Review Response

Project Name: Tyrie Pier Repair

Response To: SHL23-035 SUB1

# PIER DETAILS - PROPOSED PLAN VIEW

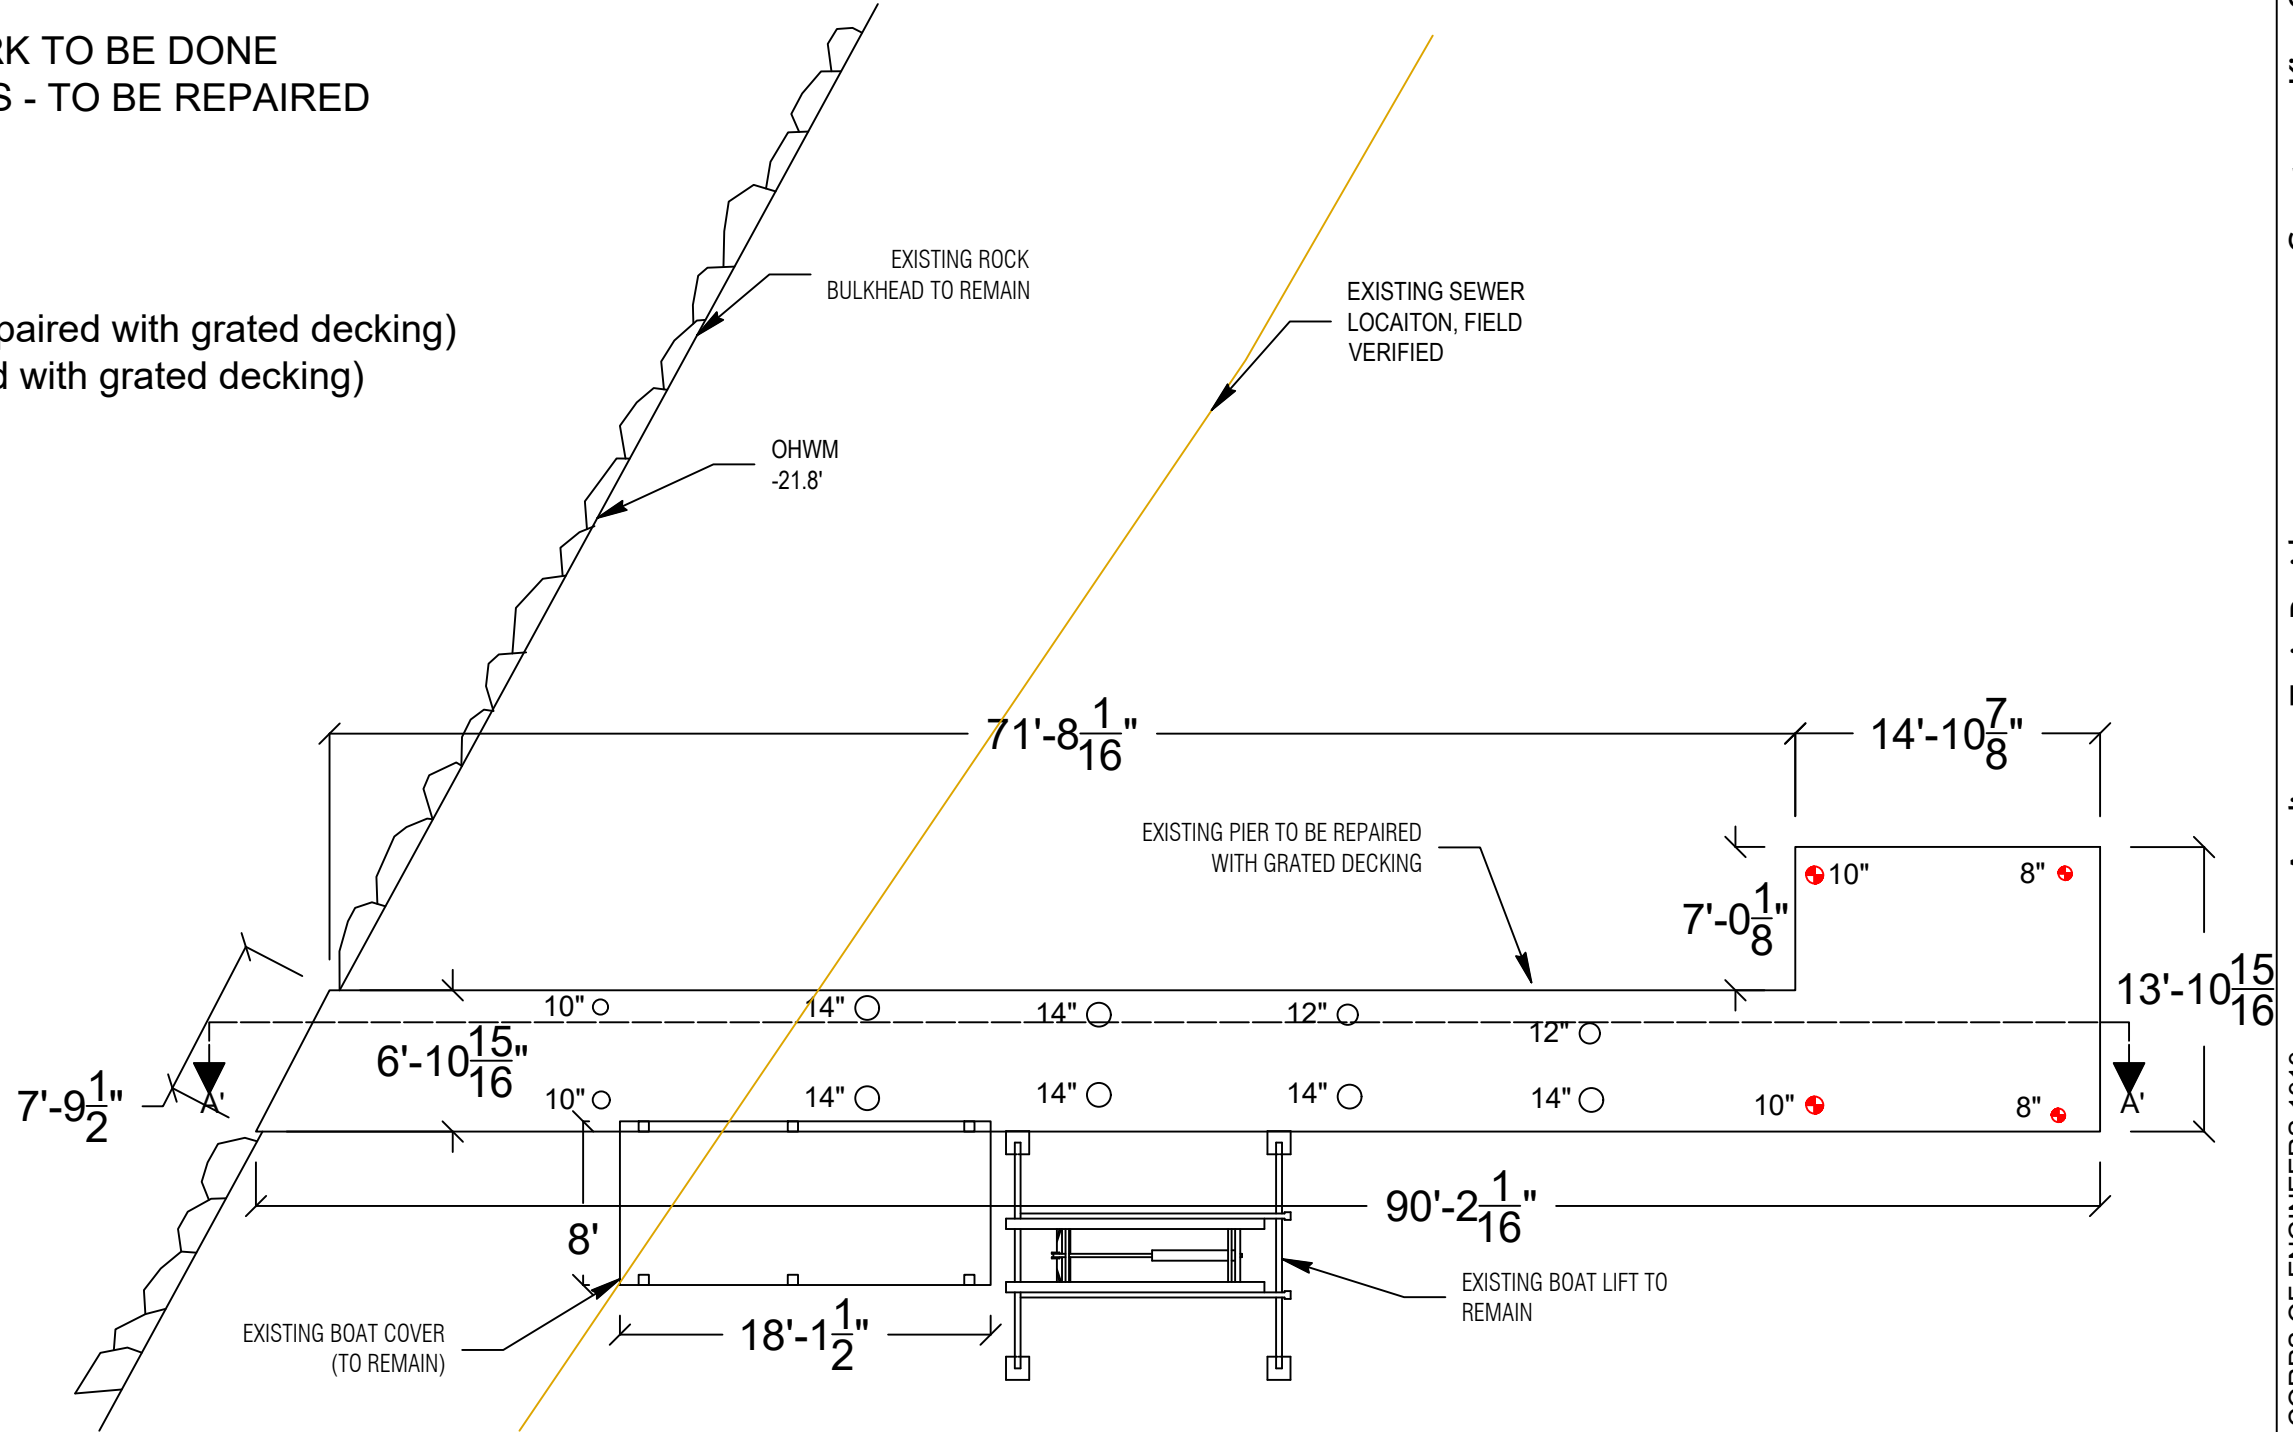
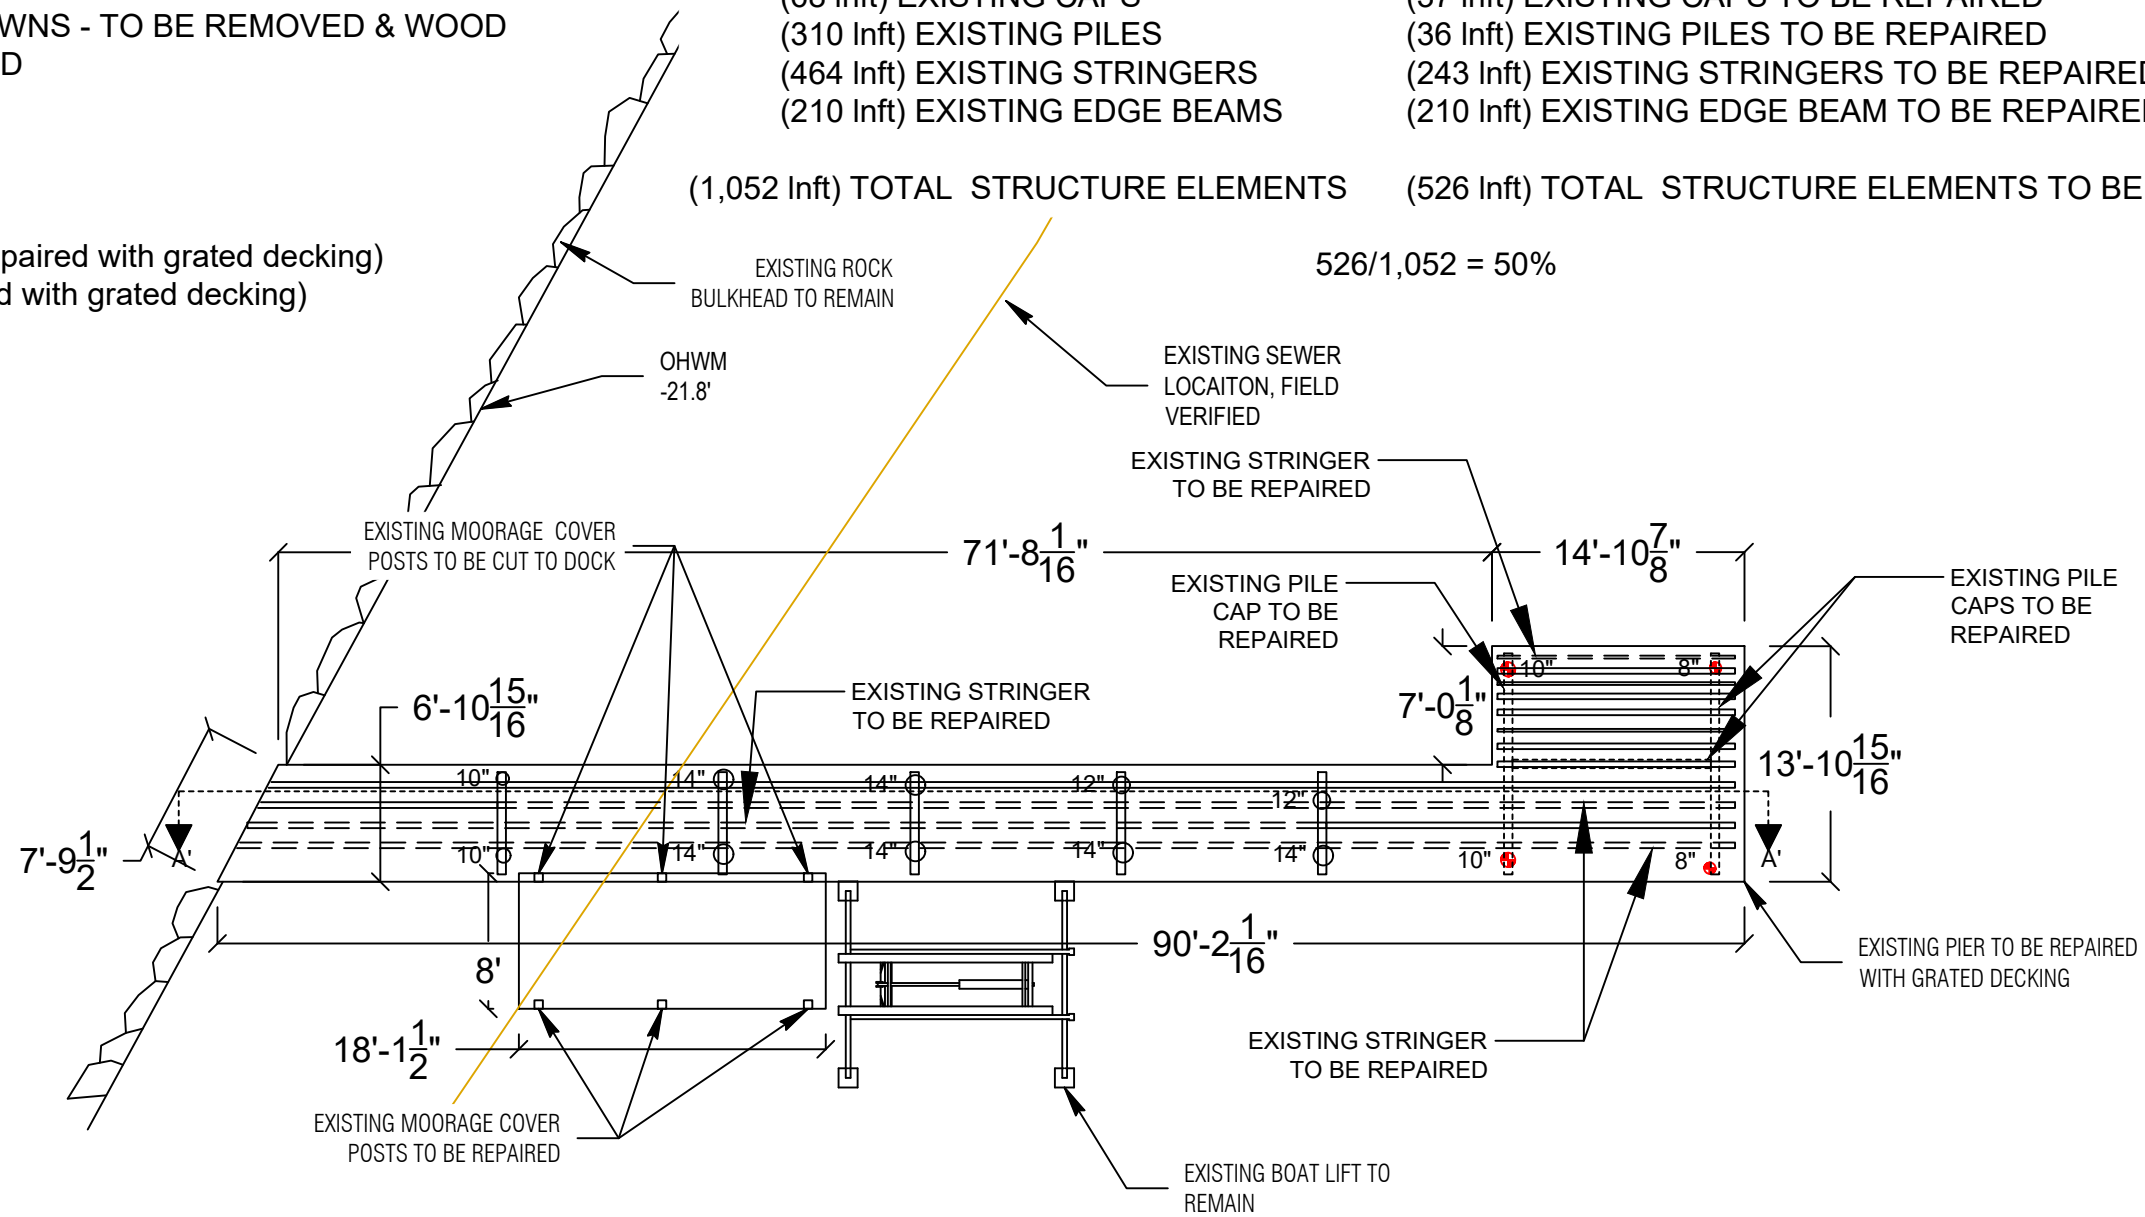
1. The plan set has been updated to include member replacement calculations on Sheet 6.
